Recommendation Report for Planning Permission for Works or Extension to a Dwelling

REF NO: WA/57/20/HH

LOCATION: 8 Prime Close
Walberton
BN18 0PL

PROPOSAL: Extension to roof and loft conversion

Project : Roof Extension
Title : Floor Plans
Drawing N.O. : PL CC 0102 / 2020 REV A

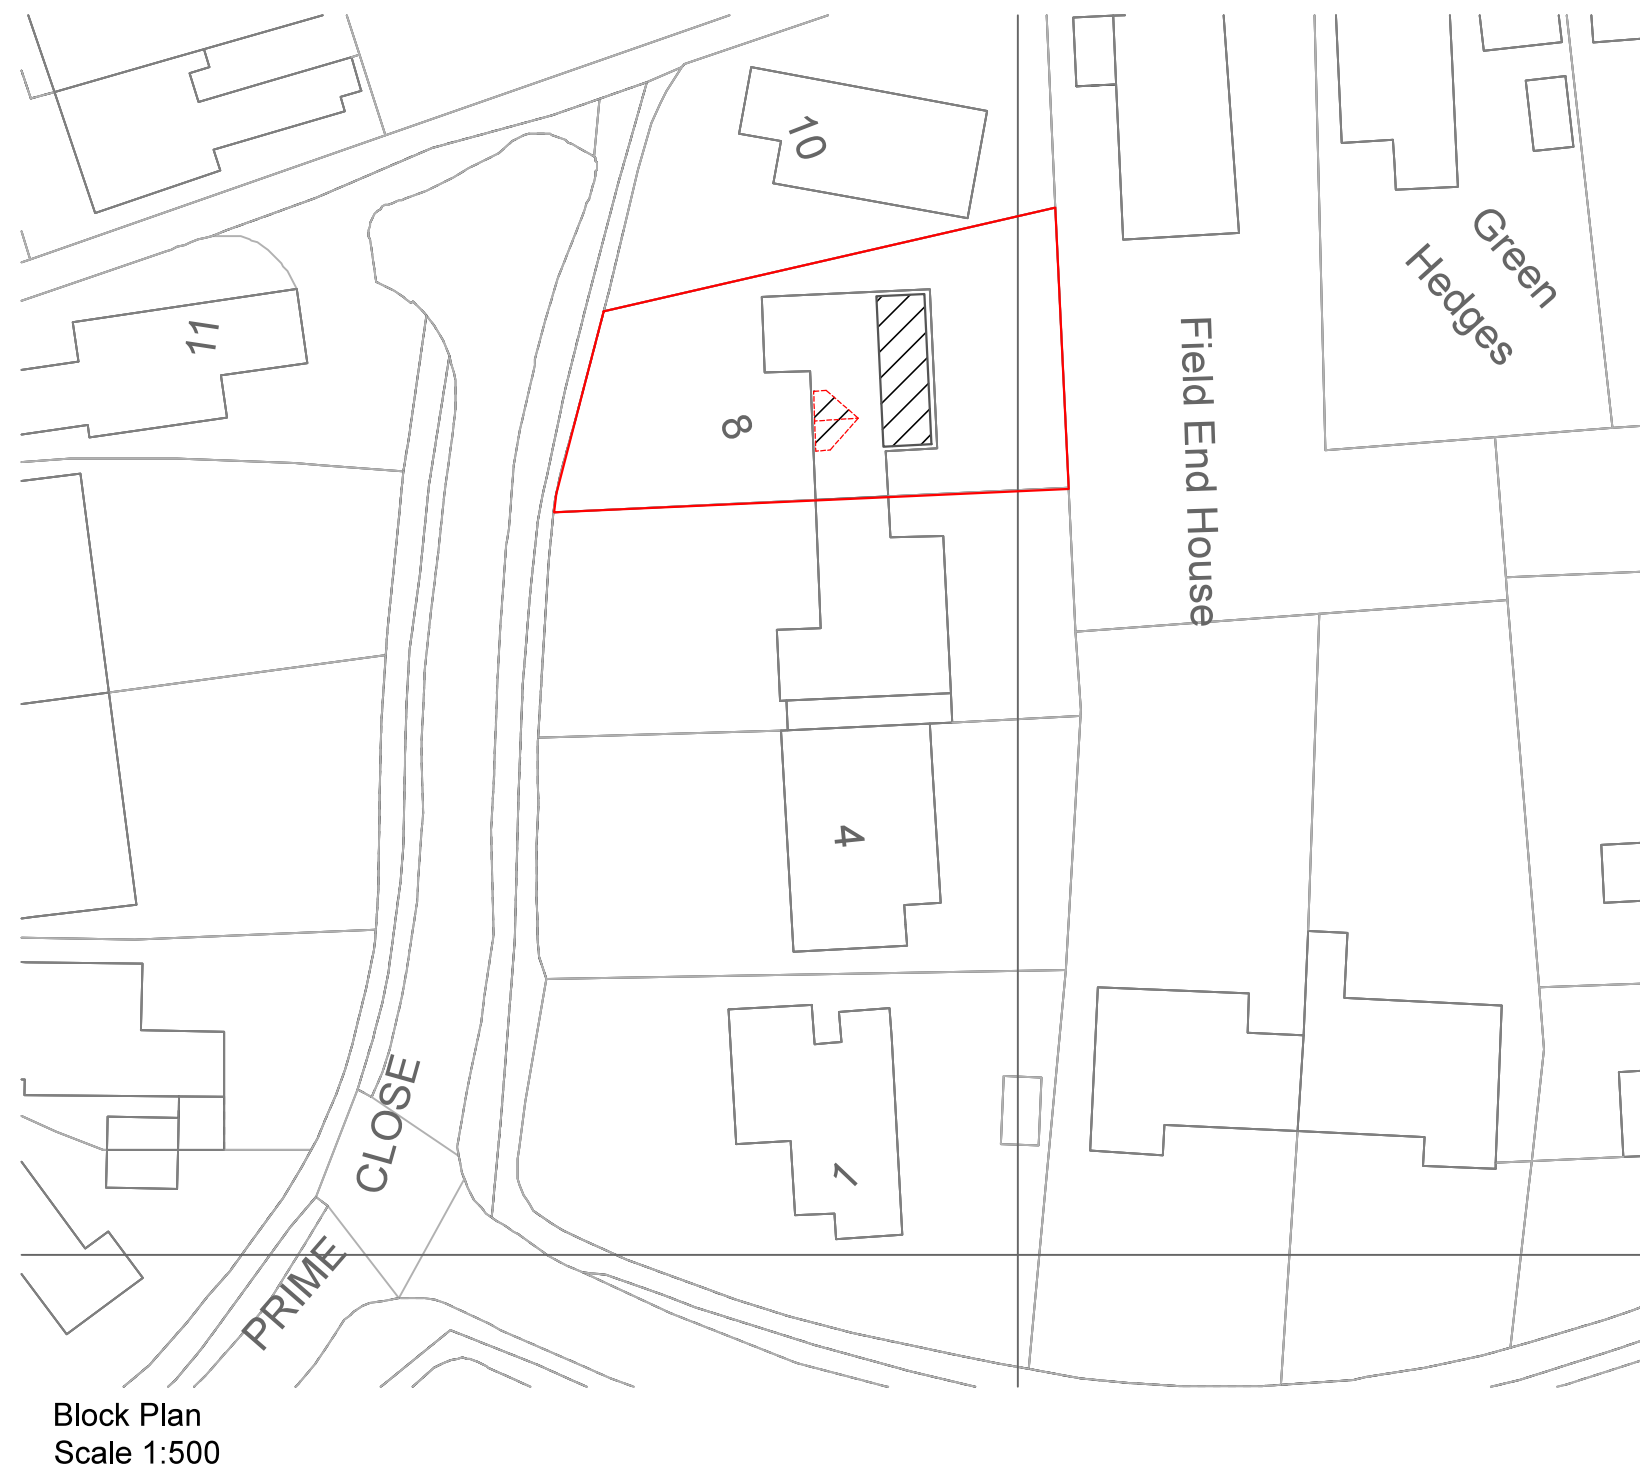
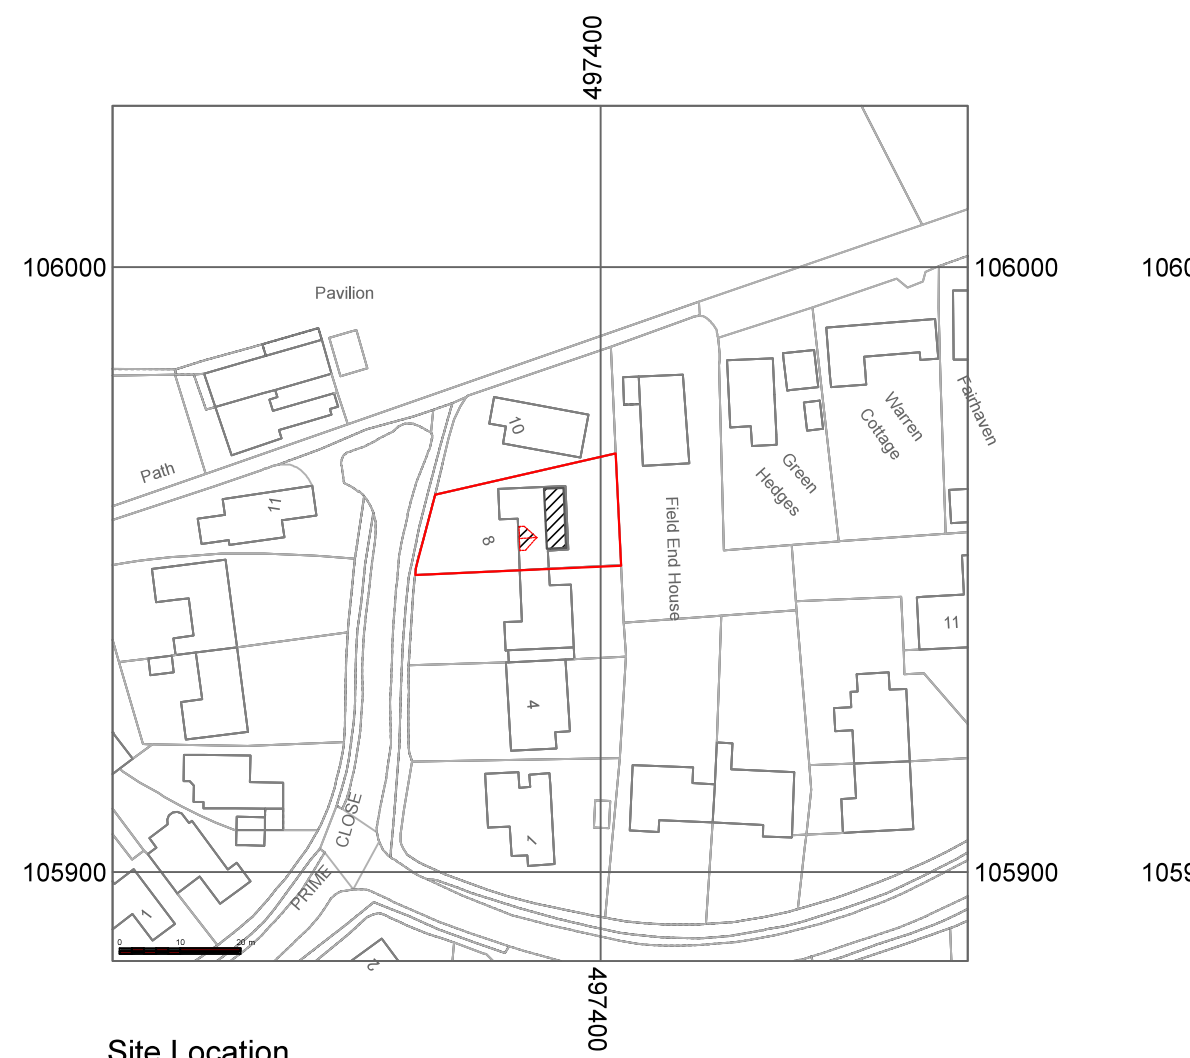
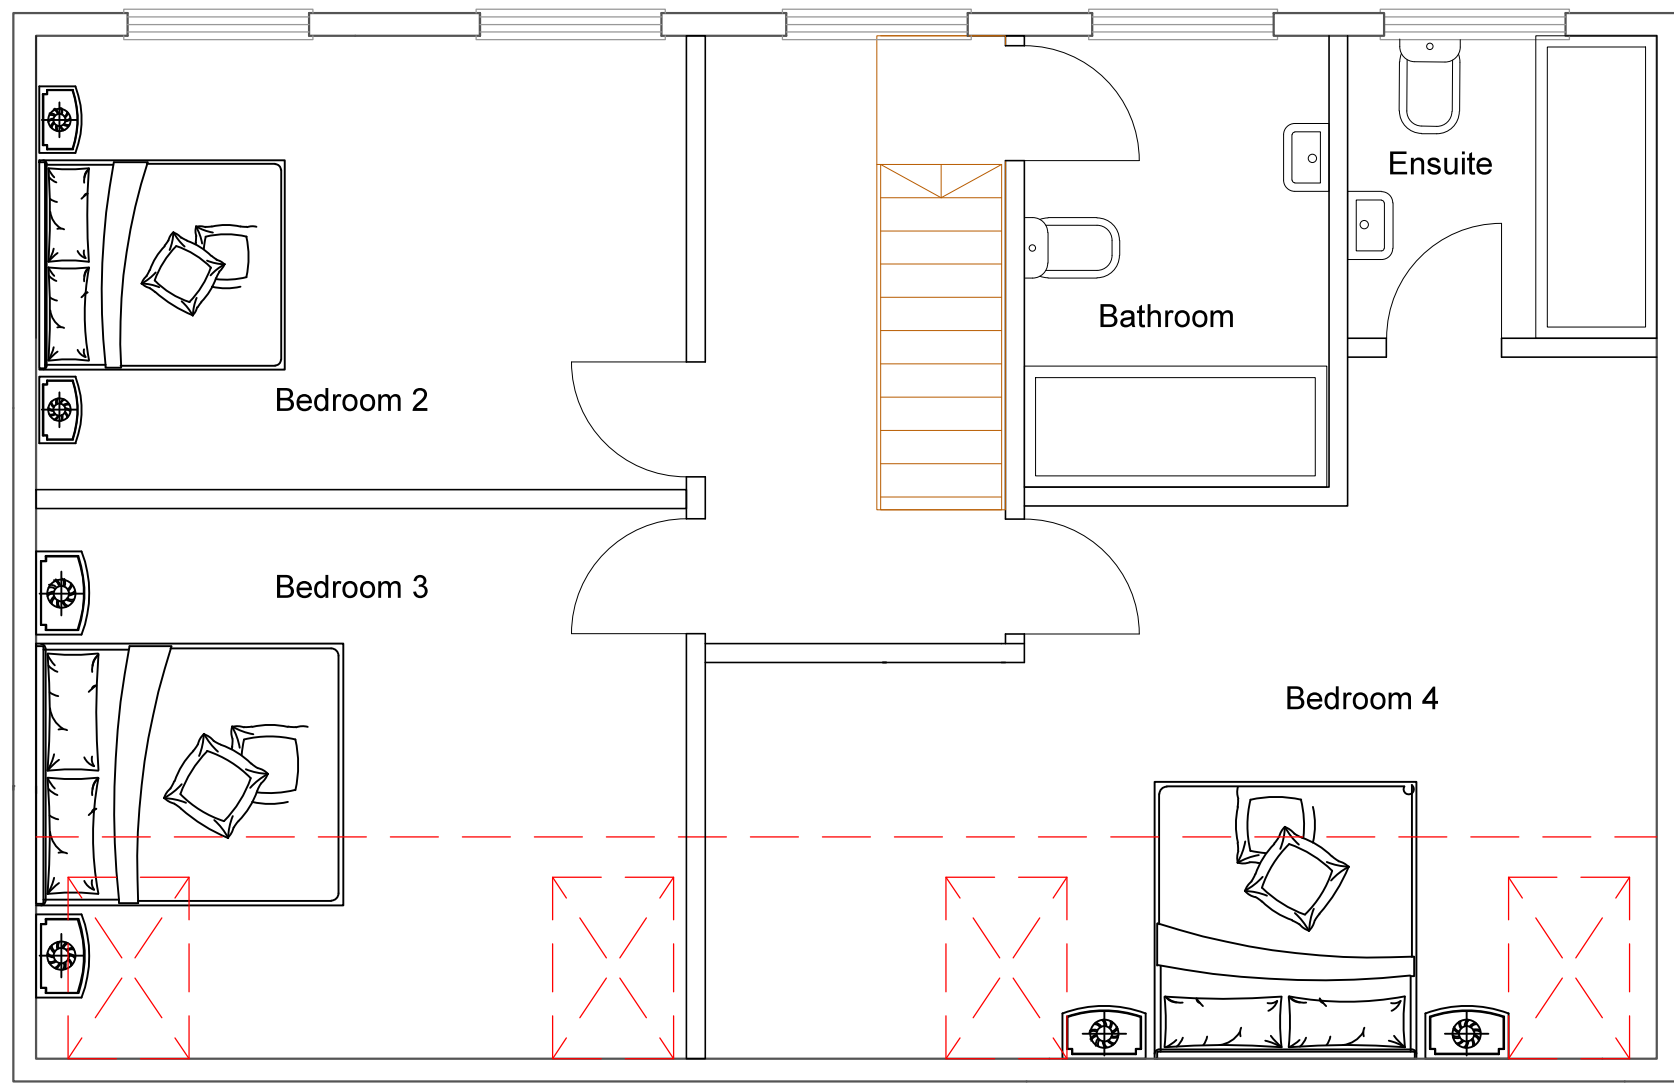
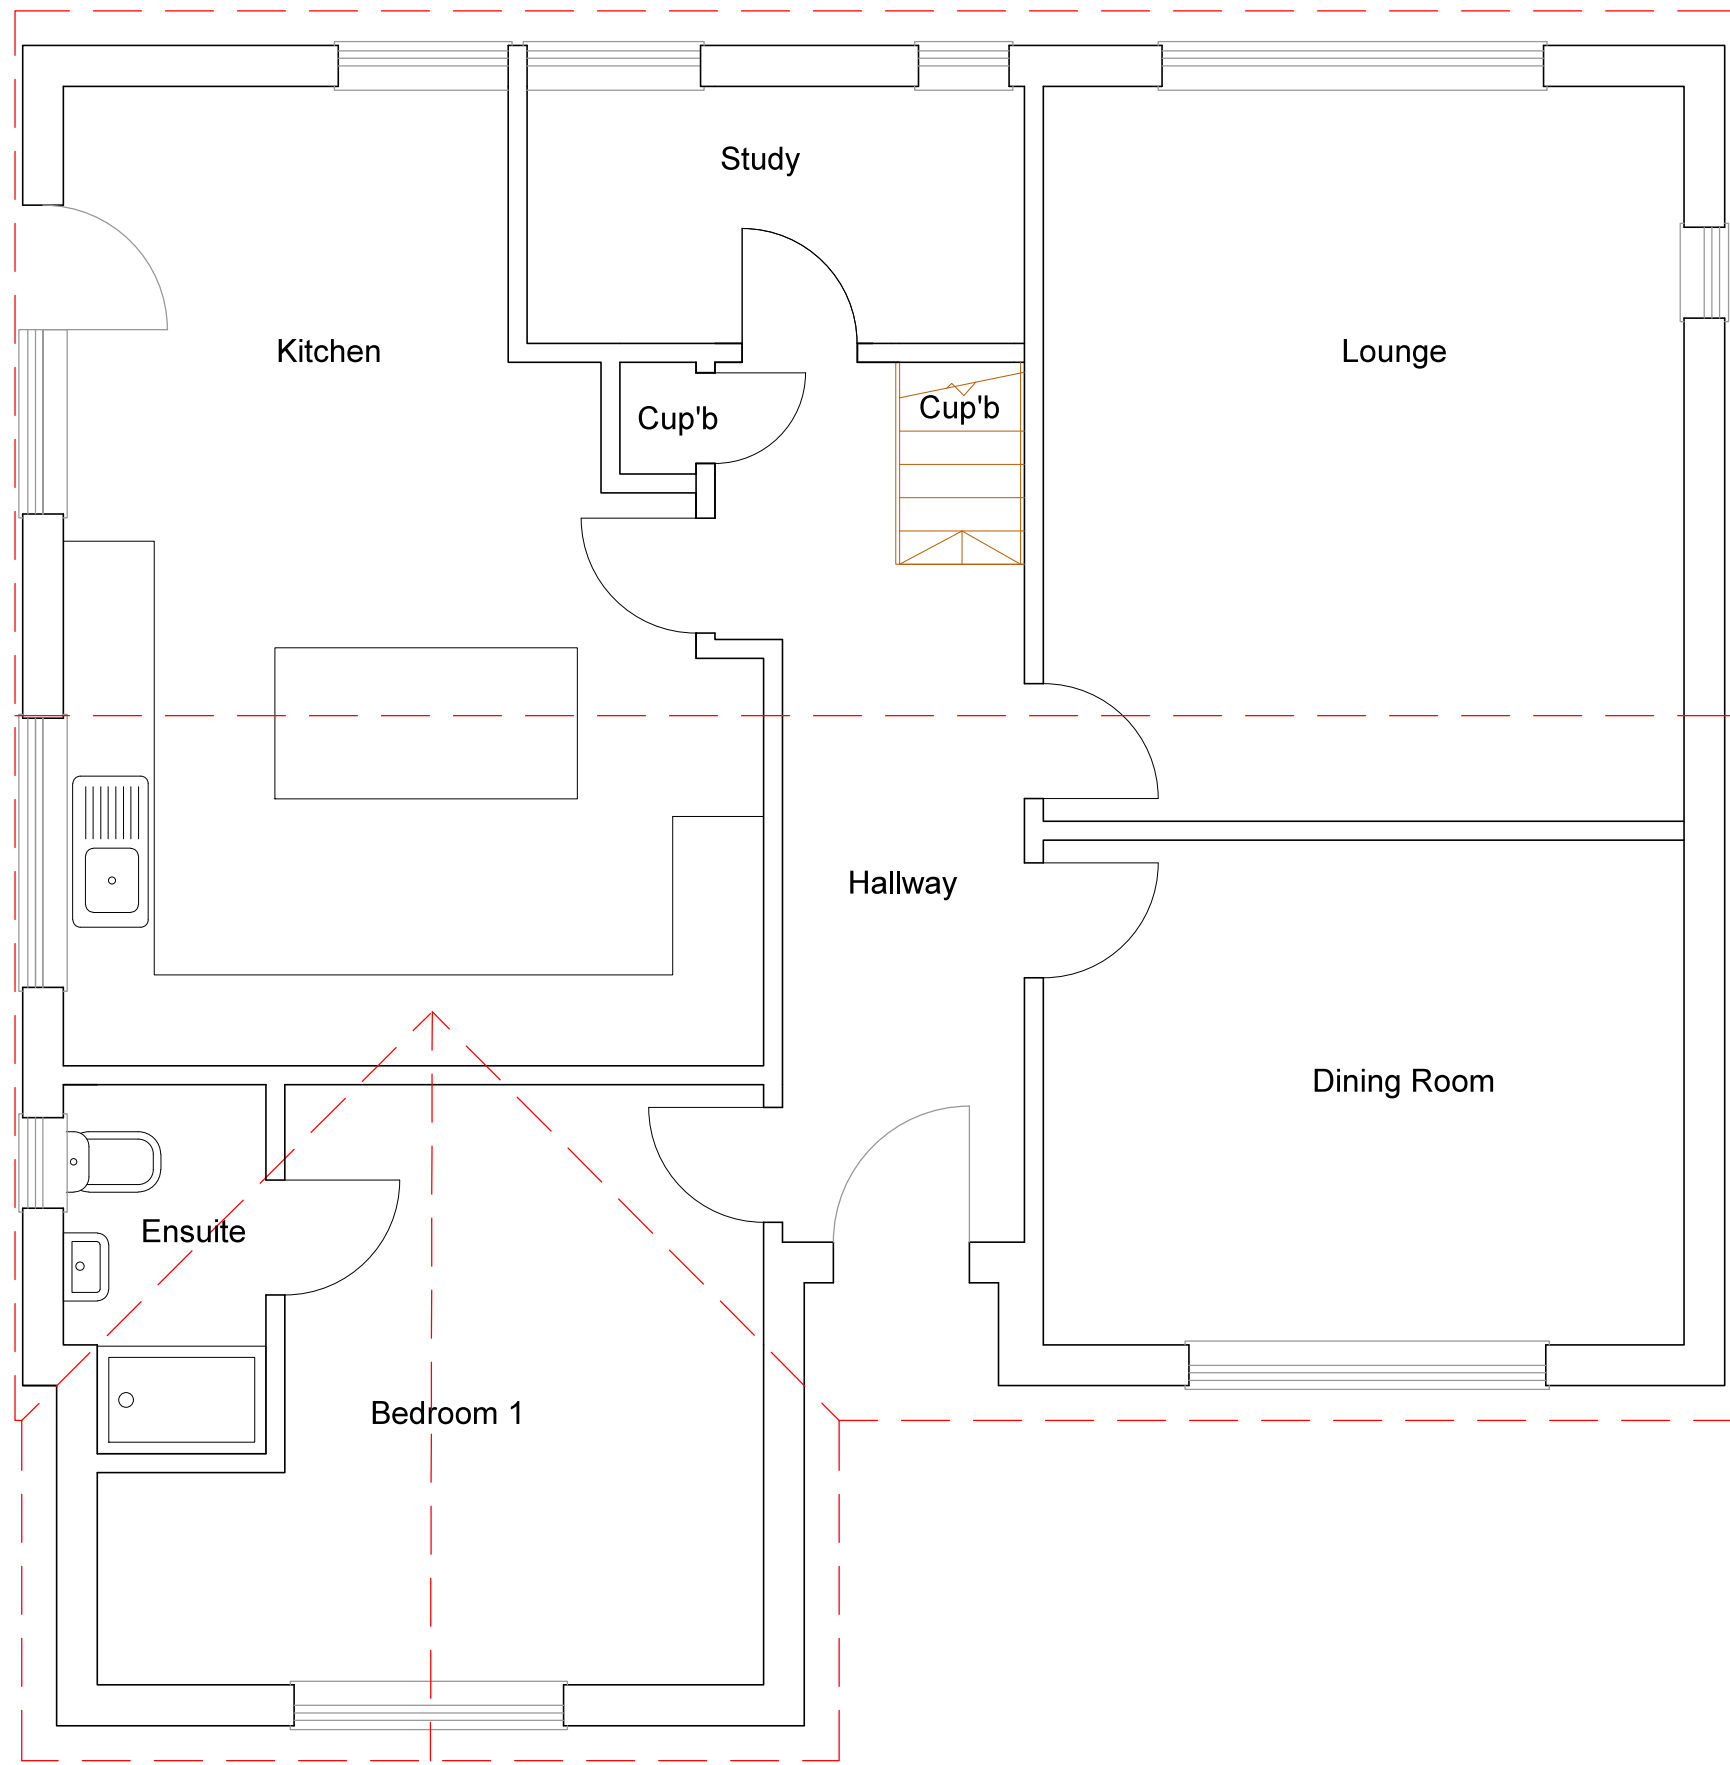
DESCRIPTION OF APPLICATION The application seeks to convert the roof space to habitable space, by way of the construction of a rear dormer extension, and the insertion of rooflights. Initially the application proposed a front dormer, however, this was changed to front Velux windows following negotiation.

- Roof Extension - Floor Plan - PL CC 0102/2020 - Rev. A - 02/11/2020
- Roof Extension - Elevations - PL CC 01/01/2020 - Rev. A - 02/11/2020
